Your Ref: OWPC12222
Our Ref: FG/198/16/PL 29-11-2016
Please ask for:
Andrew Wood

Demolition of existing house with erection of 2 storey building comprising of 8No.
residential 2 bedroom flats & associated external works
1 Sea Drive Ferring

Thank you for your internet representation made on 26th January 2017 which has been recorded as '**an objection**' with the comments as follows:

JOB: 1 SEA DRIVE, FERRING, WORTHING BN12 5HD
DWG: PROPOSED SITE PLAN

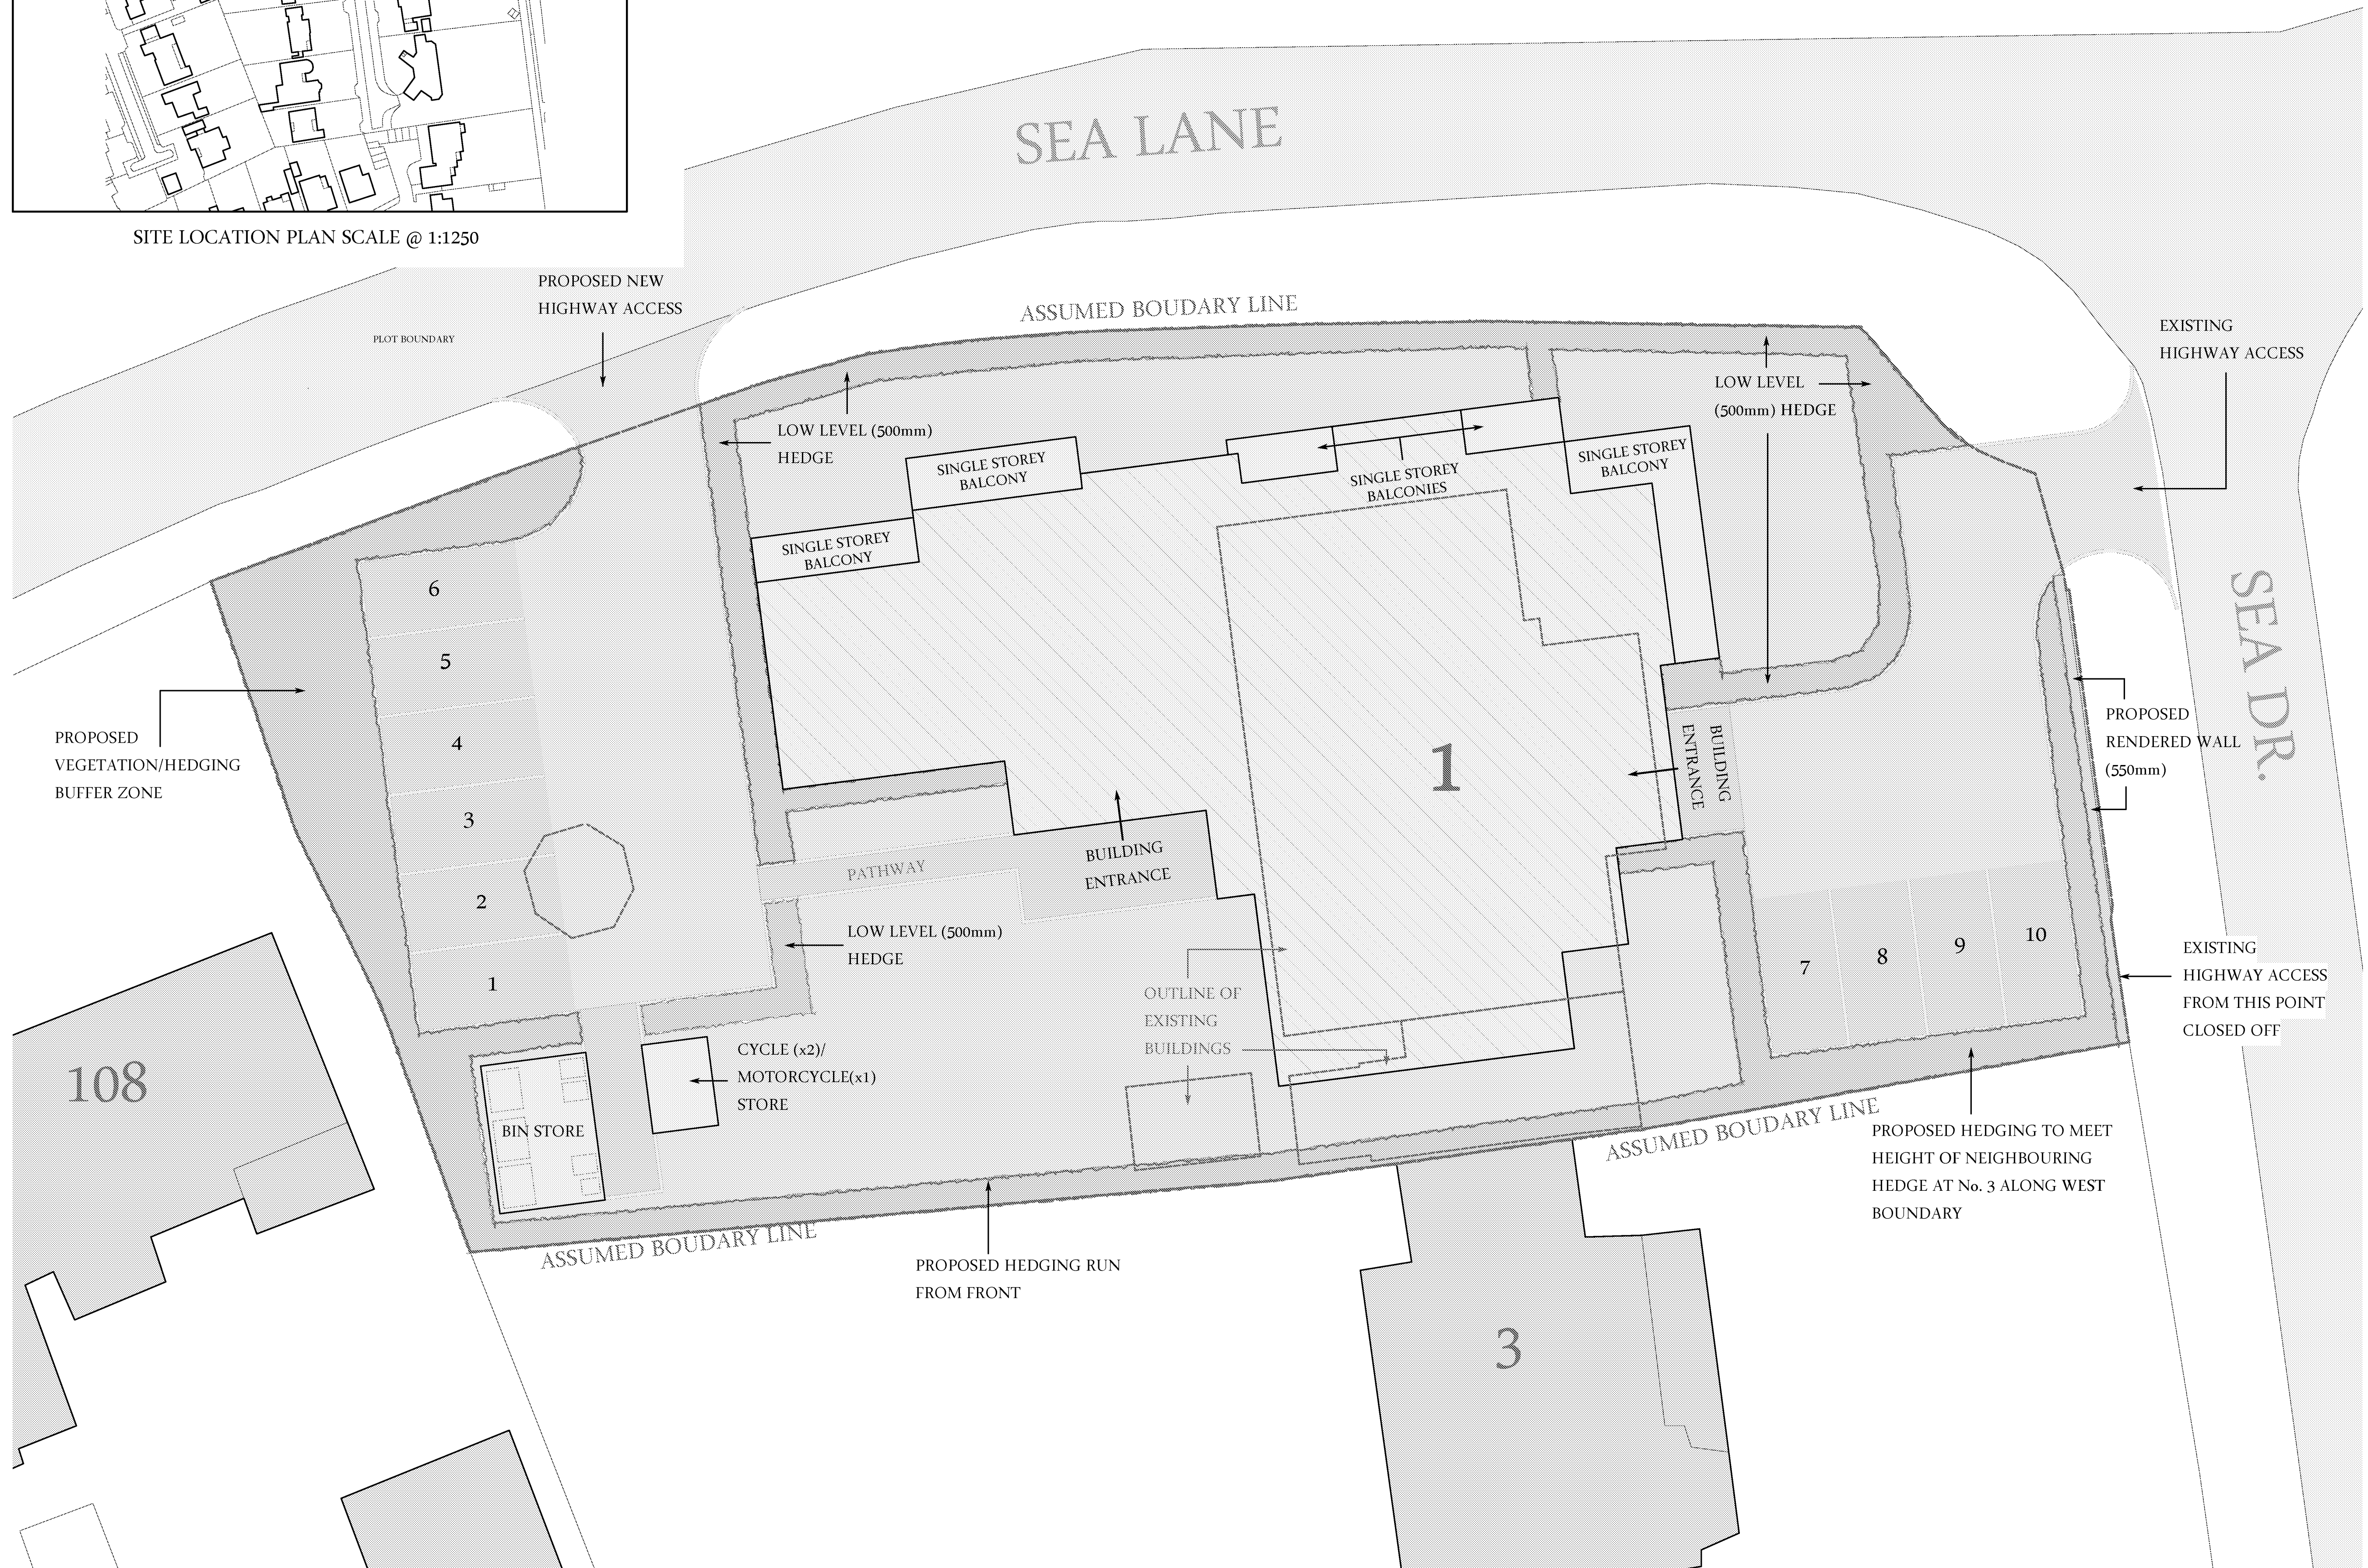
The plans show an over development of the site with very little amenity space remaining on the site. This lack of space has been identified in the Design and Access statement which suggests residents use the beach and greensward to the south and south-east rather than on site gardens.

The current site has an open garden which is in keeping with the 'gap' on the west side of Sea Drive. The proposed development contravenes GEN7 (vi) as this open space is not retained.

6 Car spaces and a new access to Sea Lane will add further risk to cyclists along the popular National Cycle Route 2 and therefore contravenes GEN7 (vii)
